**Consultation Response from KC,
Lead Local Flood Authority**

2025/91147 George Hotel, St George's Square, Huddersfield, HD1 1JA

Date Responded: 28/05/2025.

Documents reviewed by the LLFA:

Geo-Cellular Surface Water Attenuation Tanks

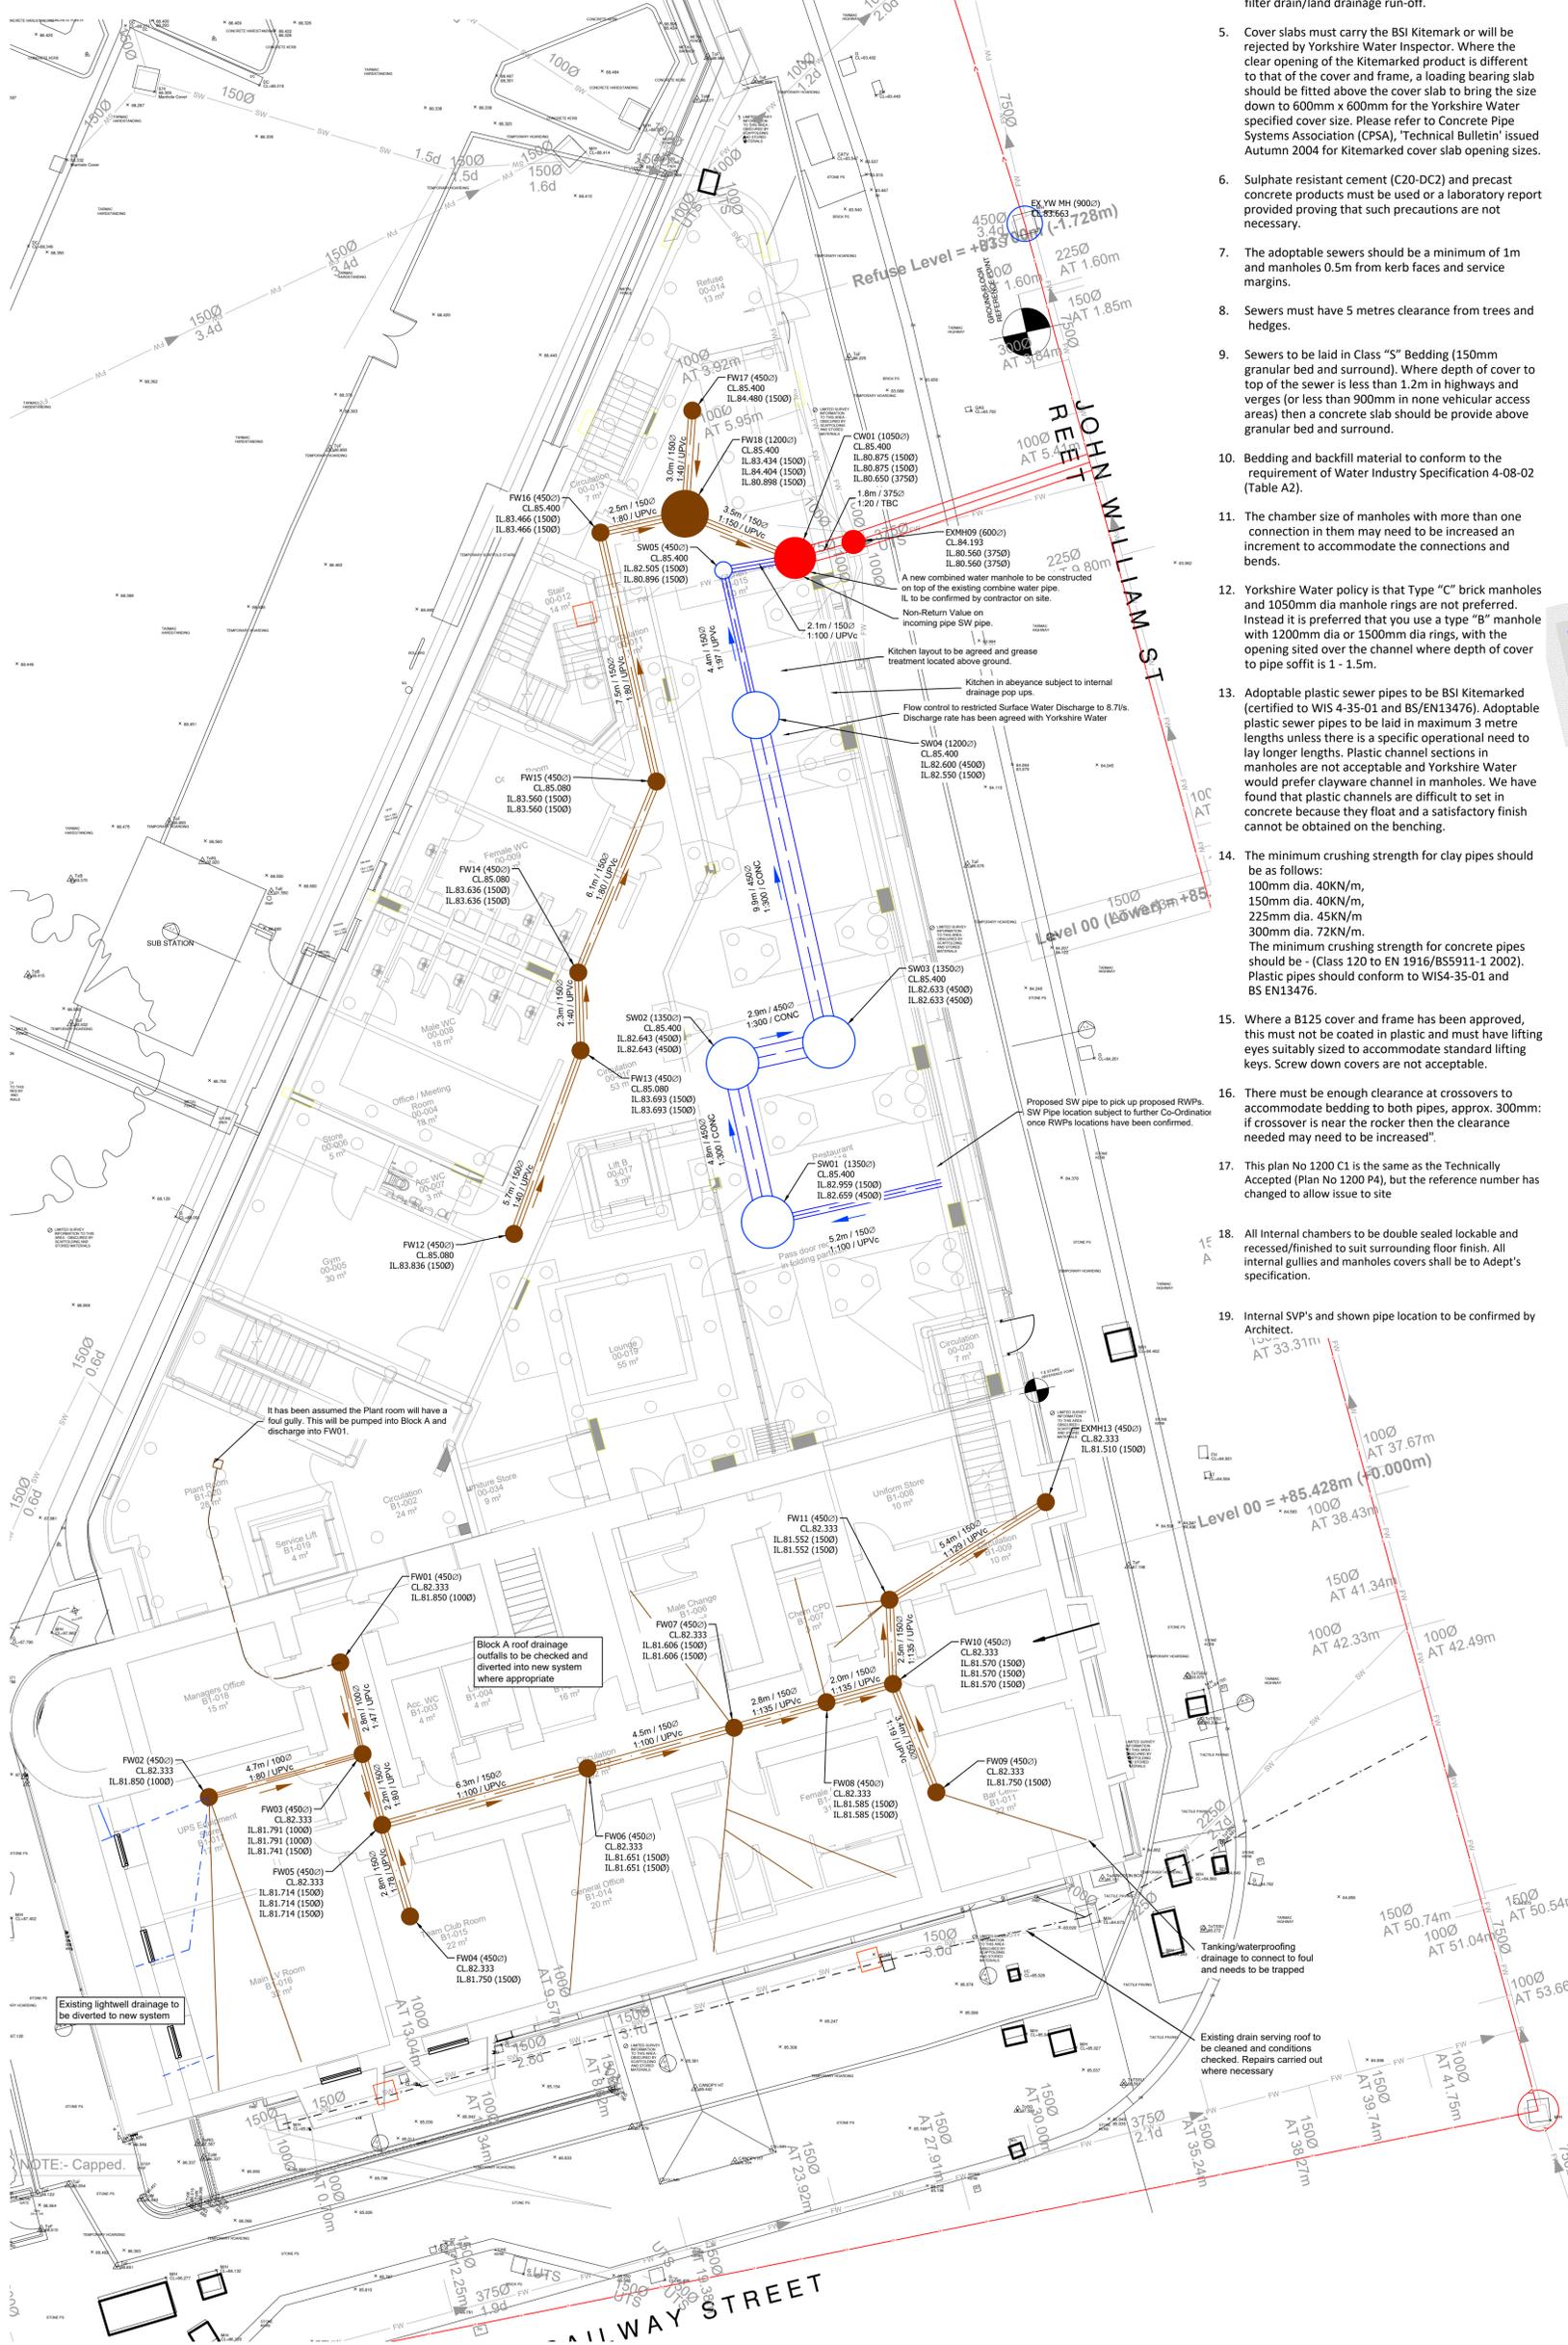
The LLFA notes that a geocell tank is proposed in the on the plan in Appendix C of the Drainage Strategy Report both in the Key and the notes at the top of the drawing, however its location is not shown on the plan – please confirm its location.
